Cottam Solar Project

Schedule of Changes (Deadline 2)

PINS Reference: EN010133
Document Reference: EX1/C8.1.7_A
The Infrastructure Planning (Examination Procedure) Rules 2010
Rule 8(1)(k)

- Key**
- Site Boundary
 - Soft Landscape**
 - Existing tree canopy
 - Existing hedge to be retained
 - Existing hedge to be removed
 - Existing hedge reinforced with irregularly spaced native tree planting

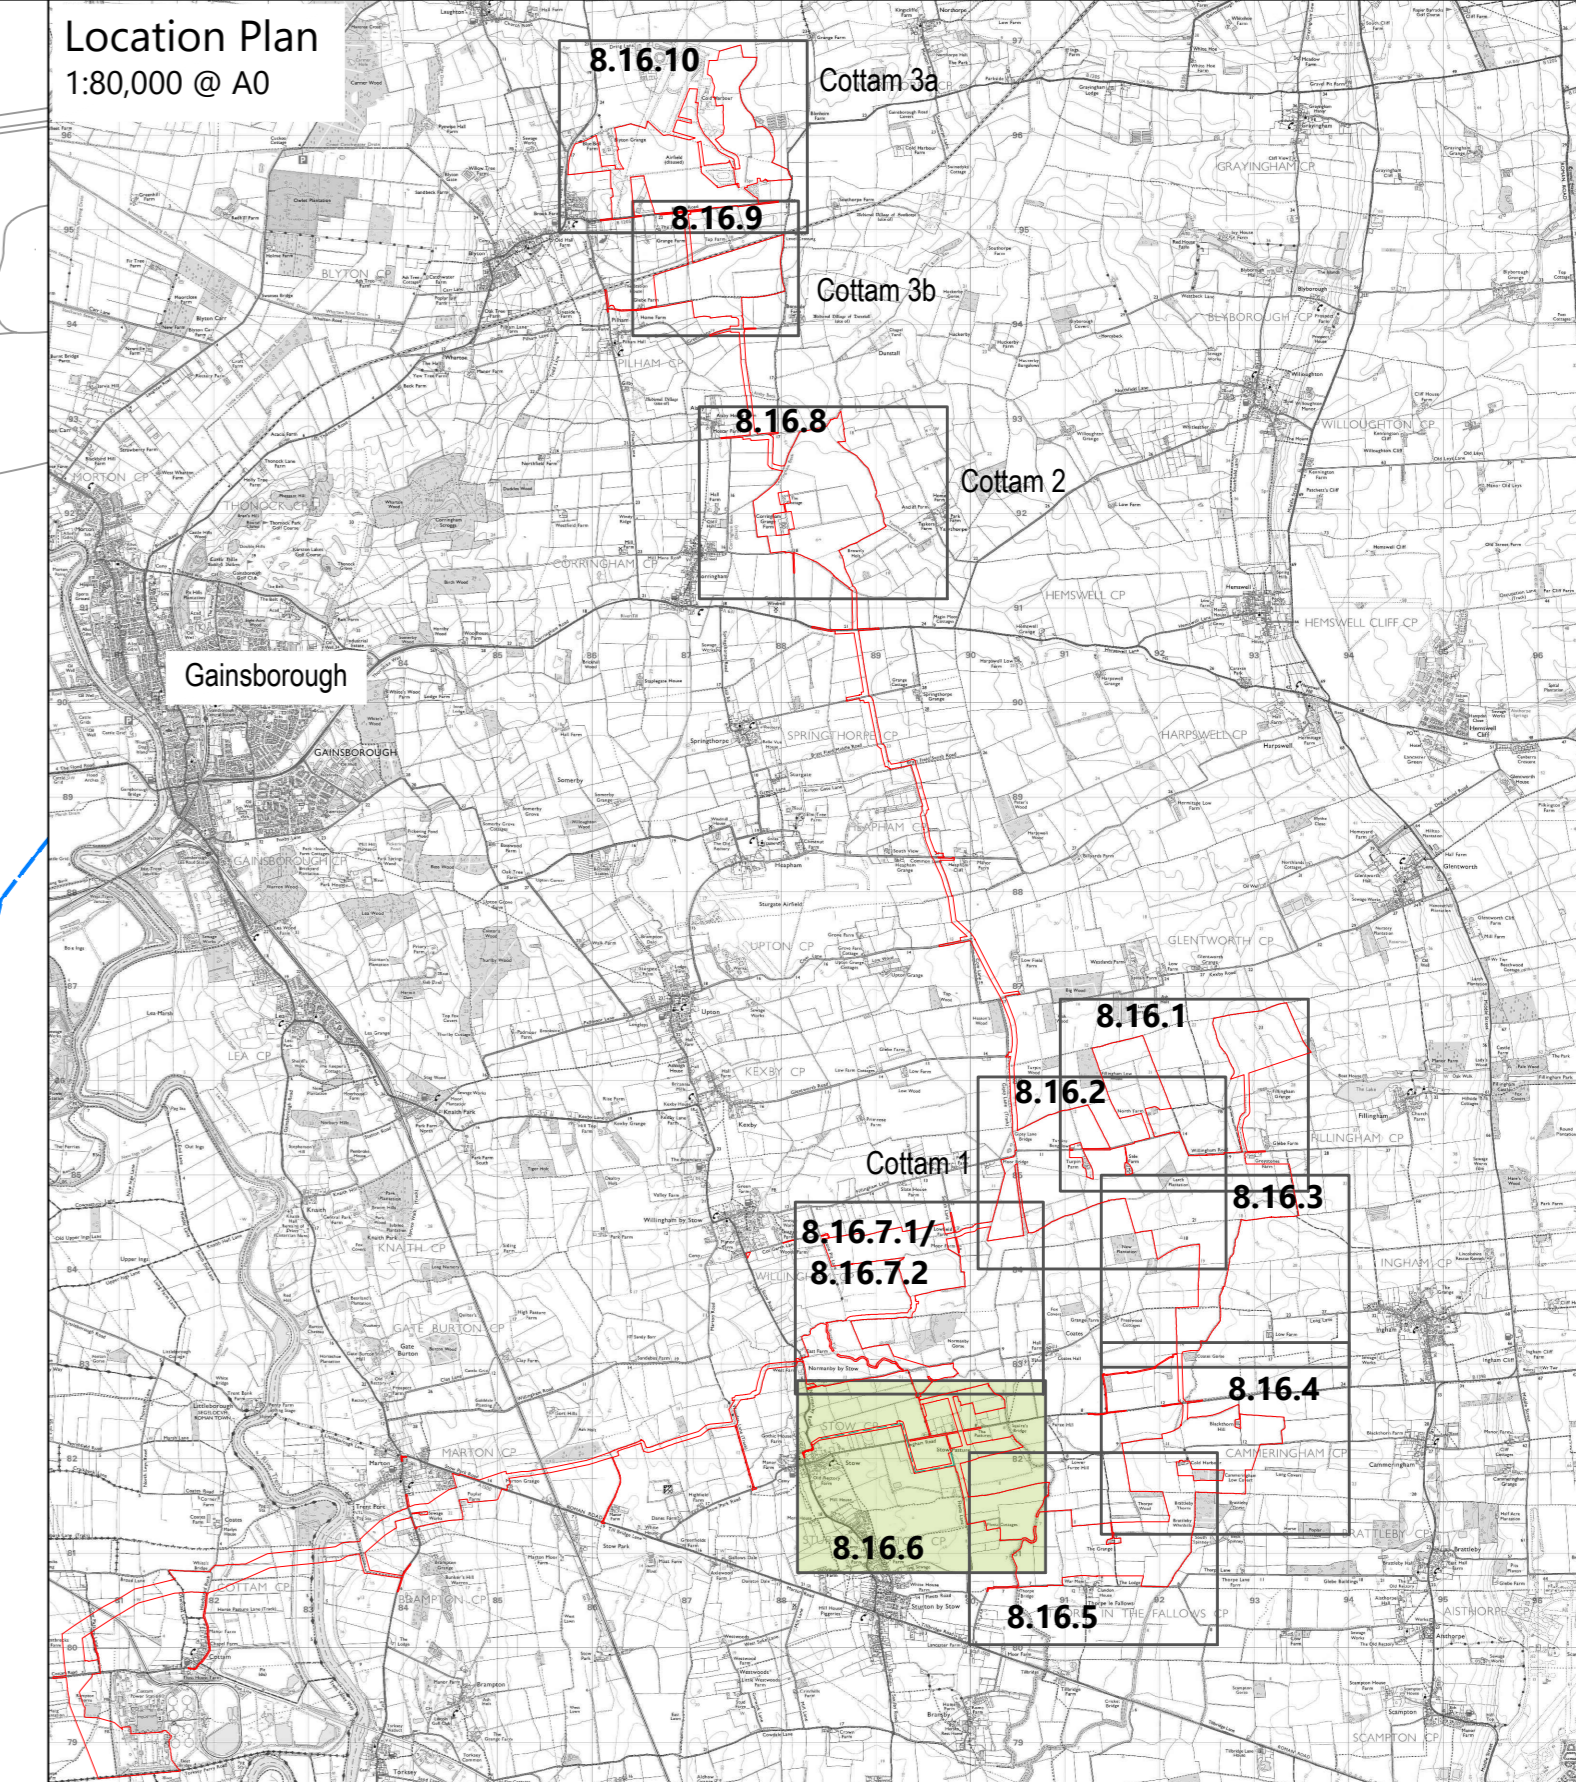
C6.4.8.16.1 to C6.4.8.16.10 Landscape and Ecology Mitigation and Enhancement Plans	[APP-305 to APP-315]	Revision A [EX1/ C6.4.8.16.1_A to EX1/ C6.4.8.16.10_A]	Deadline 1 17 October 2023	Correction of typos, to show additional hedgerows to be removed and to provide clarity of IDB Drain locations.	Minor editorial changes for clarity.
C6.5 ES Non-Technical Summary	[APP-336]	Revision A [EX1/C6.5_A]	Deadline 1 17 October 2023	Paragraphs 6.3.14 to 6.3.16, and 6.3.20 to 6.3.21, updated clarifying as to which part of the Site, and which assessment period the effects relate to.	To provide clarity and consistency and minor editorial changes.
